RECOMMENDATION FOR PLANNING AND DEVELOPMENT COMMITTEE

APPLICATION REF: 3/2026/0442

LISTED BUILDING CONSENT FOR REPOINTING WORKS TO NORTH WALL OF MUSEUM BUILDING. CASTLE MUSEUM, CLITHEROE CASTLE, CASTLEGATE, CLITHEROE, BB7 1AZ.

Plan showing wall to receive re-pointing works

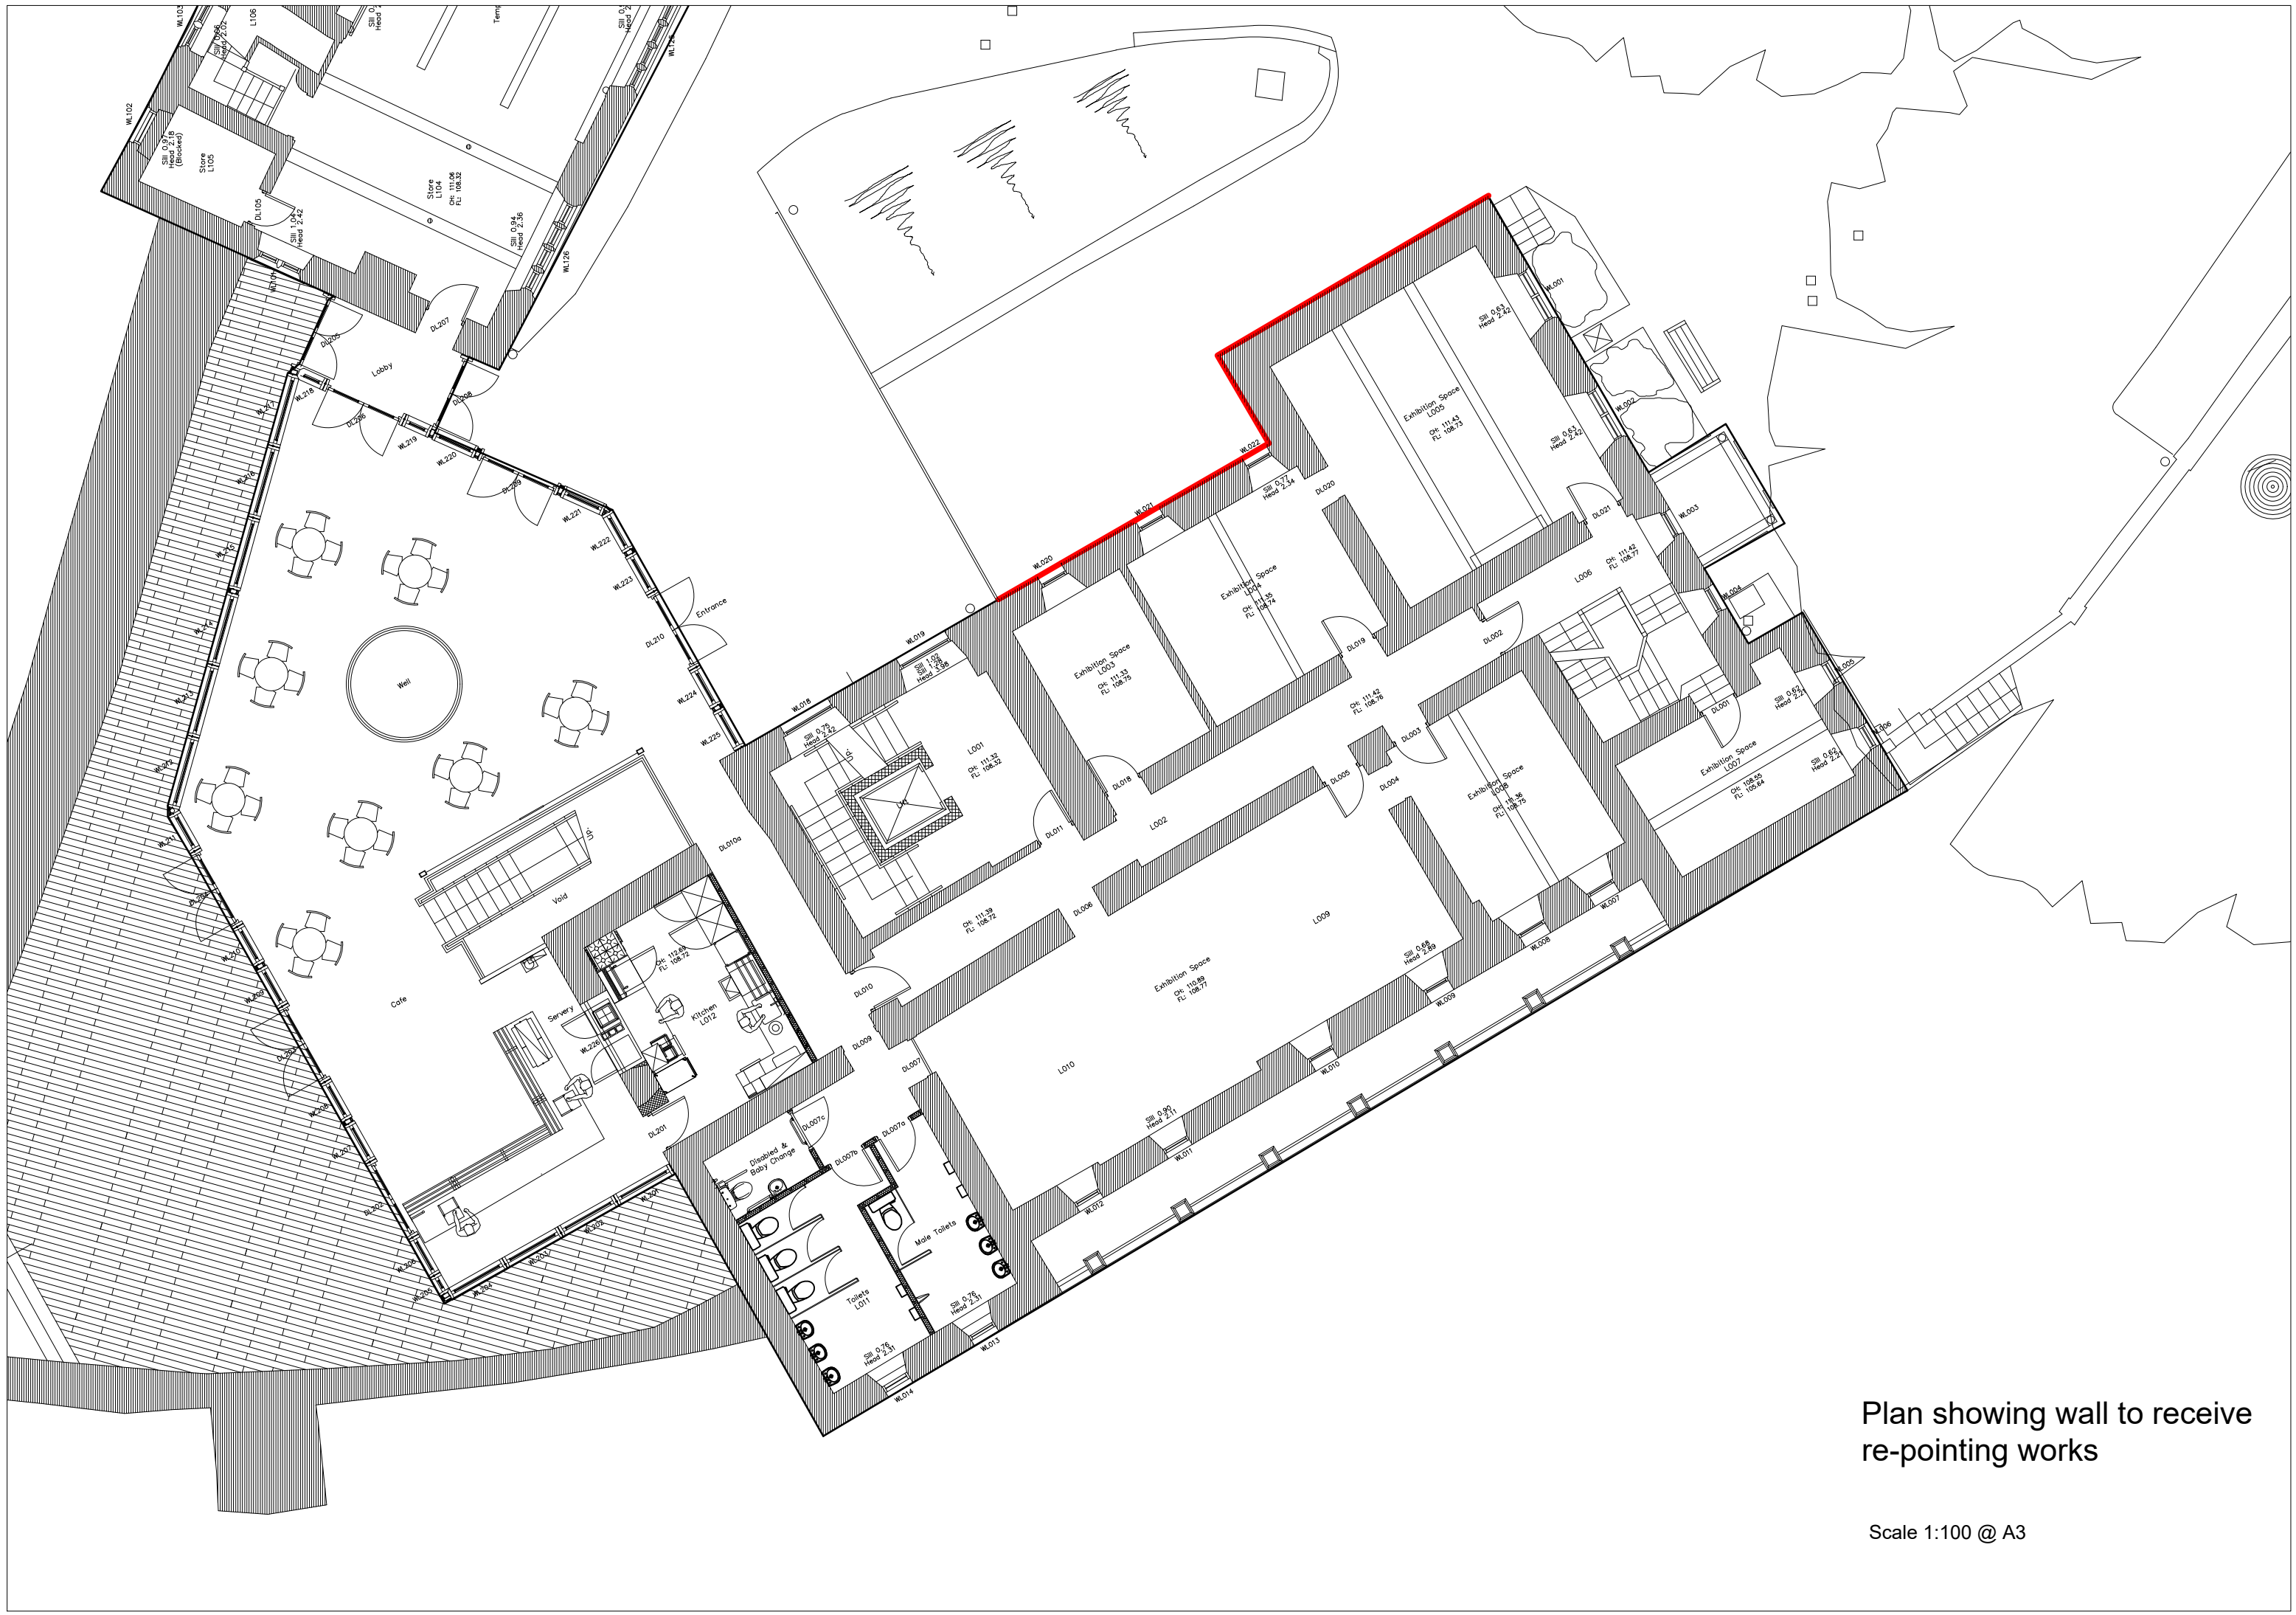
- 2.1 The application seeks Listed Building Consent for repointing works to the north wall of the Museum building.

- 5.1.10 To address the continued water ingress affecting the museum building, which is having a detrimental impact on both the internal appearance of the building and certain structural elements and decorative finishes, it is proposed to repoint the northern elevation using lime mortar. The existing downpipe and hopper will be temporarily removed and stored on site prior to the commencement of the works and reinstated thereafter. Existing cement-based mortar will be carefully removed by hand, and the original lime mortar raked out to a minimum depth of 30mm. The elevation will then be cleaned to remove dust and debris from the masonry joints. Any masonry units exhibiting bed splits will be replaced on a like-for-like basis. Voids within the walling will be deep packed using pinning stones and lime mortar, while larger surface areas exceeding 100mm will be repaired with new facing stone to match the existing masonry. Approximately 50% of the quoins will be lime grouted, and the elevation repointed using lime mortar, with pinning stones inserted in joints exceeding 25mm in width. The mortar will be finished flush with the masonry arris. To prevent rapid drying, the masonry will be dampened before and during the works, with hessian sheeting installed and kept damp as required, depending on weather conditions. Once the mortar has sufficiently stiffened, the surface will be worked with a churn brush to compact and texture the mortar before being lightly brushed with a brass brush to achieve a consistent finish. The completed works will then be protected for a period of seven days.

Side (North) Elevation

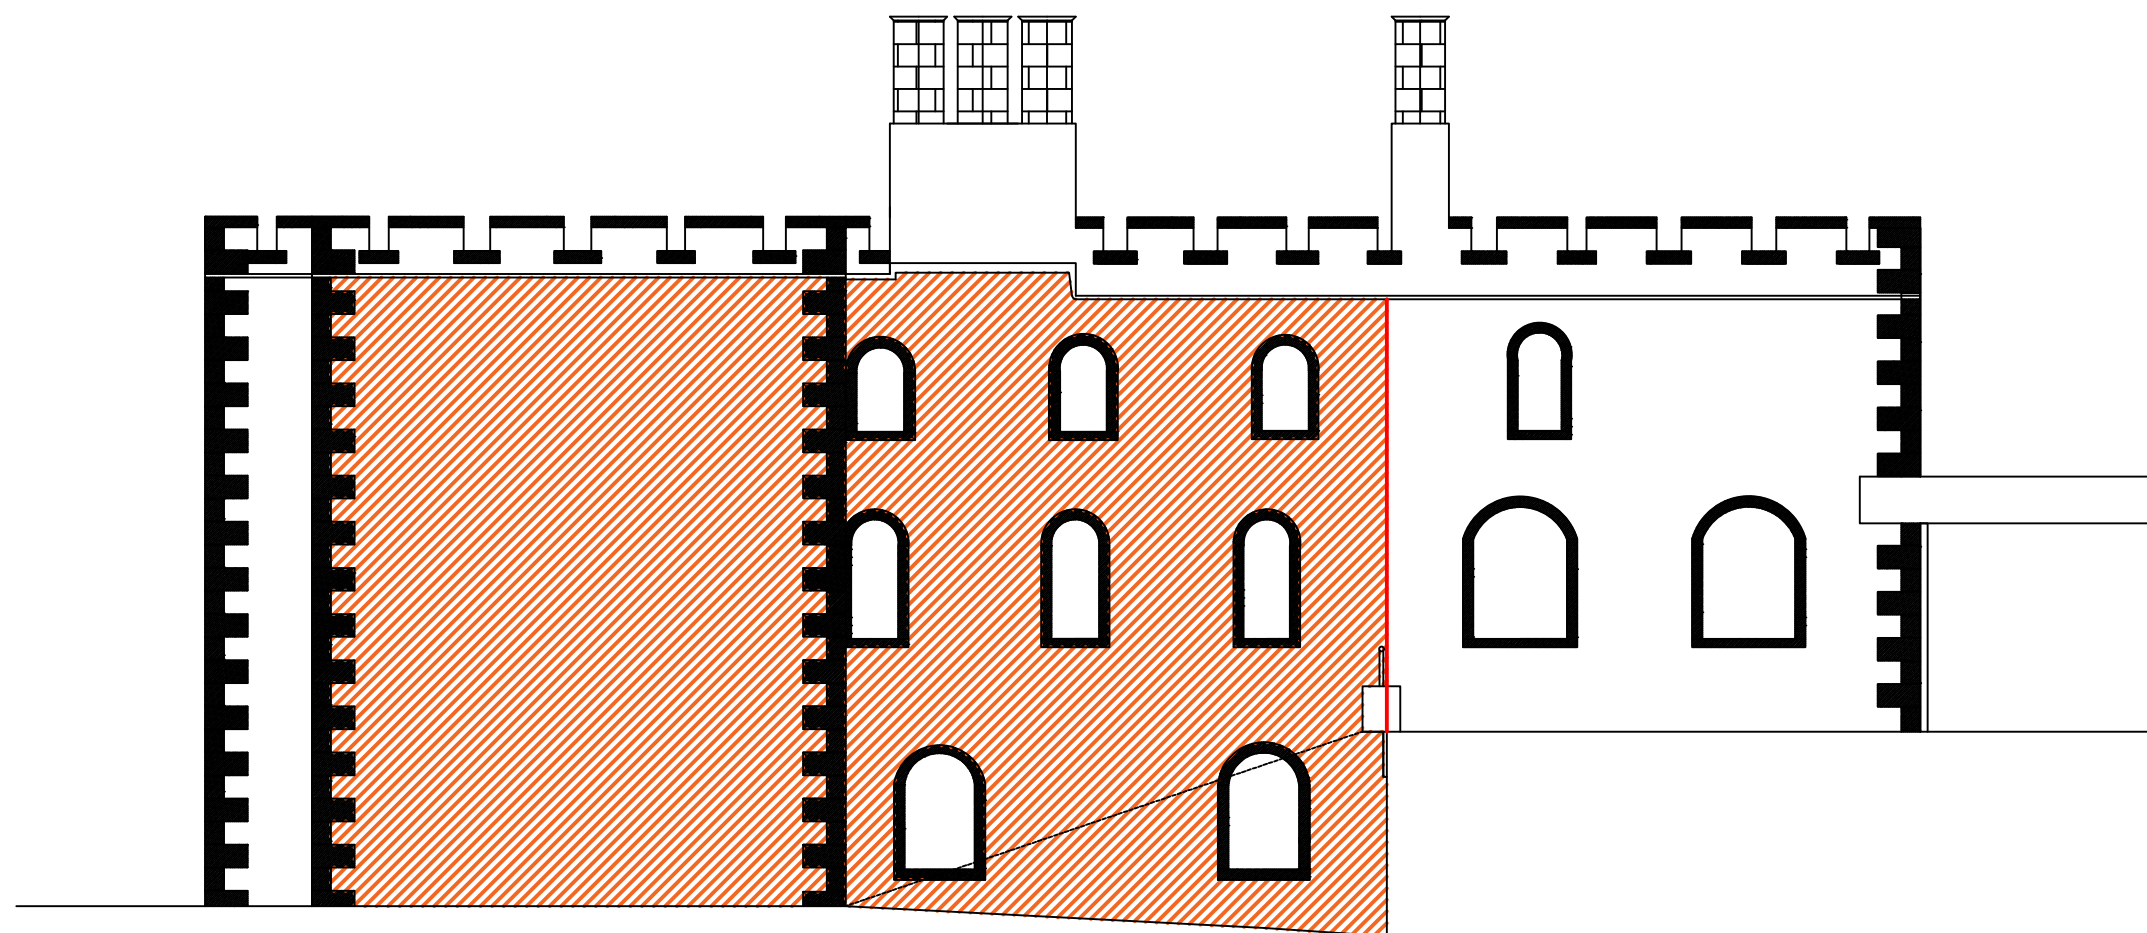
- 5.1.11 In addition, the existing downpipe and hopper will be repainted and then reinstated using stainless steel fixings.
- 5.1.12 Given the ongoing water ingress issues affecting the building, the proposed repointing works are considered to constitute a heritage benefit. The works would reduce moisture penetration and help prevent the continued deterioration of the historic fabric, thereby contributing to the long-term preservation and maintenance of the significance of the designated heritage asset.

- 5.1.13 Whilst the proposed lime mortar mix has not been specified as part of this application it is considered that this could be satisfactorily controlled via an appropriately worded planning condition.

3. No external re-pointing or other masonry repair shall take place until details of the proposed lime mortar specification for such works has been submitted to and approved in writing by the Local Planning Authority. The works shall thereafter be carried out in strict accordance with the approved details and the methodologies as specified in the submitted Application Form and Heritage Statement.
